Please ask for: Ms Iqraa Malik
Email: iqraa.malik@terraquest.co.uk
Telephone: 01212341390
Our Ref: R/171/21/HH
Your Ref:
Date: 9th July 2021

Application for Planning Permission for Works or Extension to a Dwelling

Development: Erection of a gazebo and hip to gable loft conversion including a change of boundary treatment
Location: 2 Windmill Drive Rustington BN16 3HJ

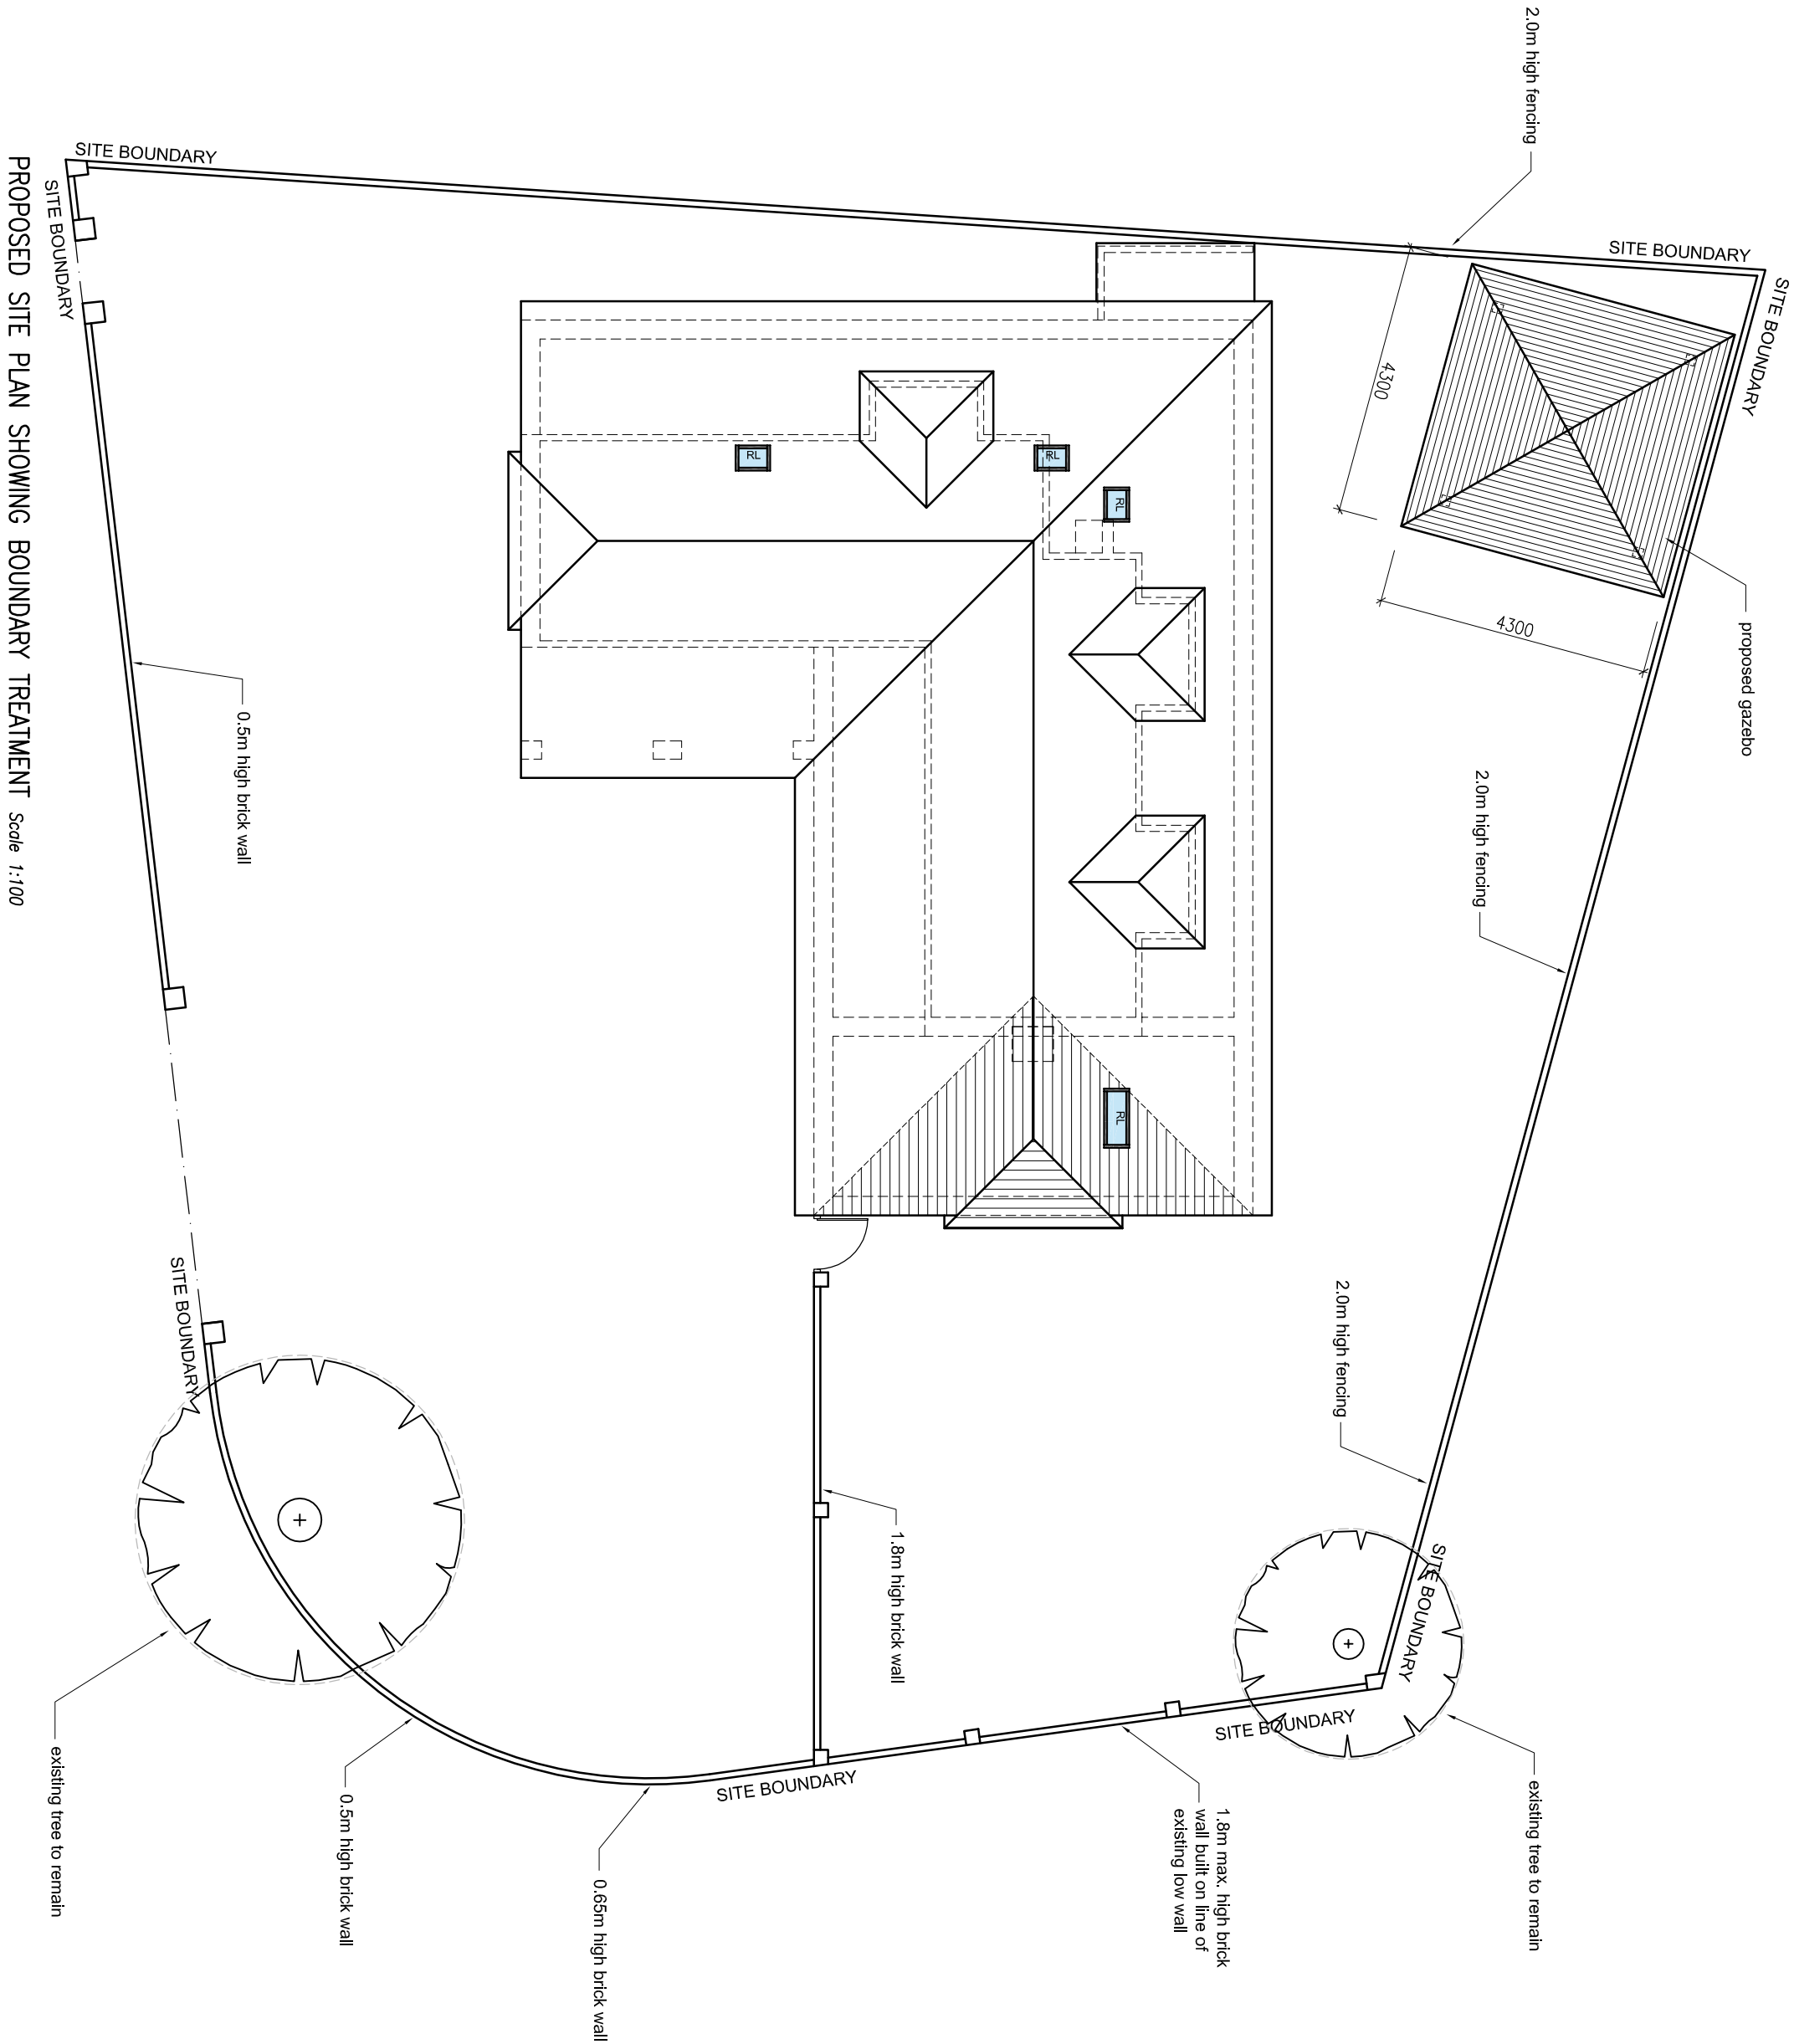
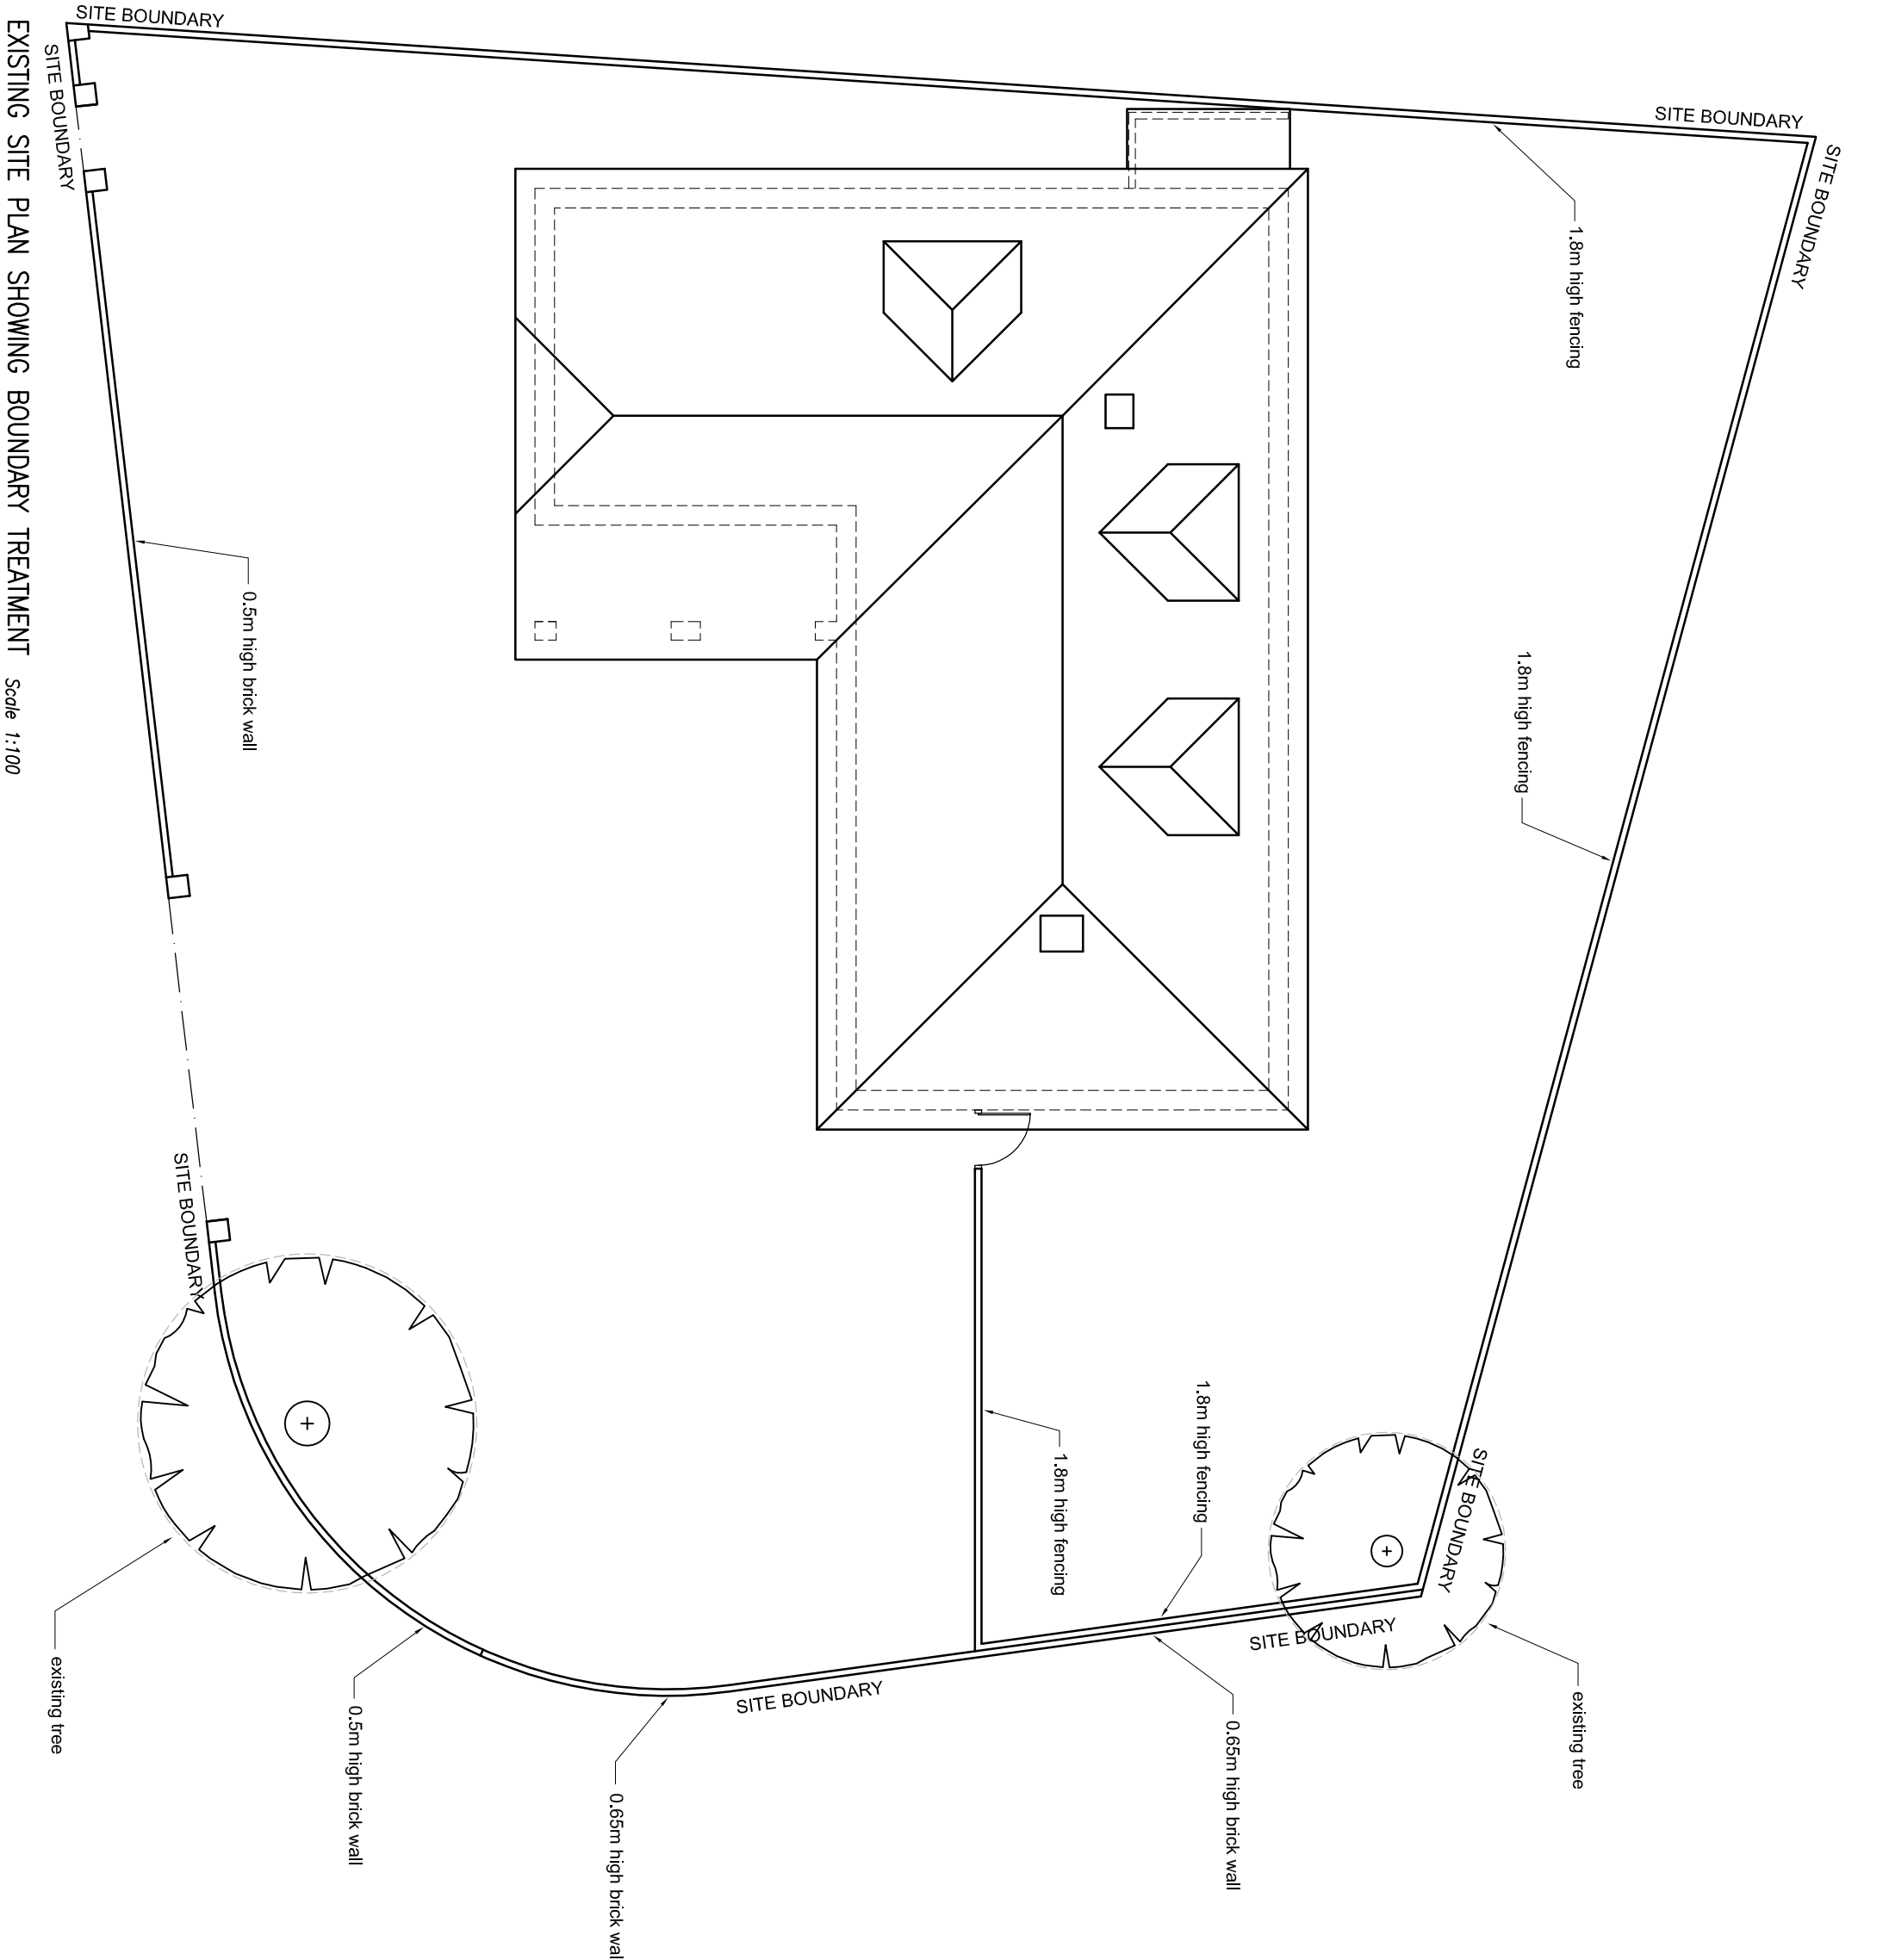
Block Plan

You are required to have dimensions from the proposed extension(s) to all relevant site boundaries. Please amend.

GAZEBO FRONT ELEVATION (NORTH)

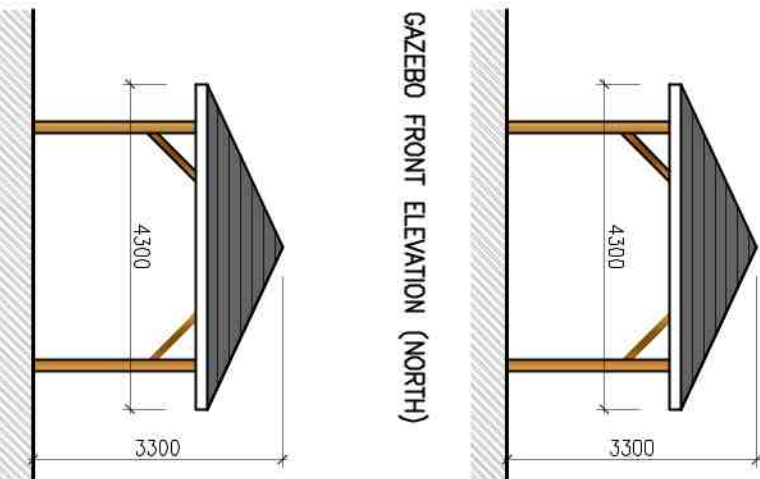
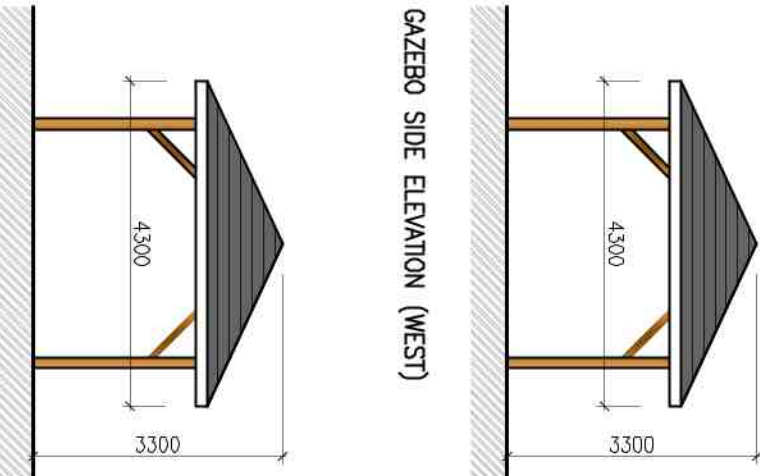
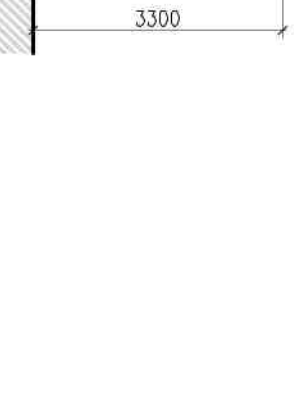
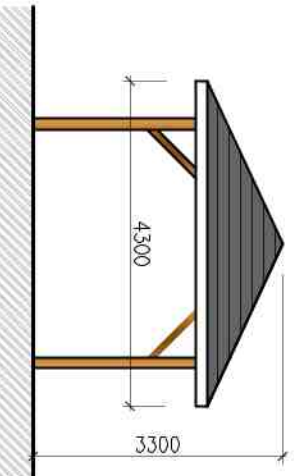
Elevations

Please submit proposed elevations of the gazebo at a scale of 1:50 or 1:100. Further details can be found in the Validation Requirements List.
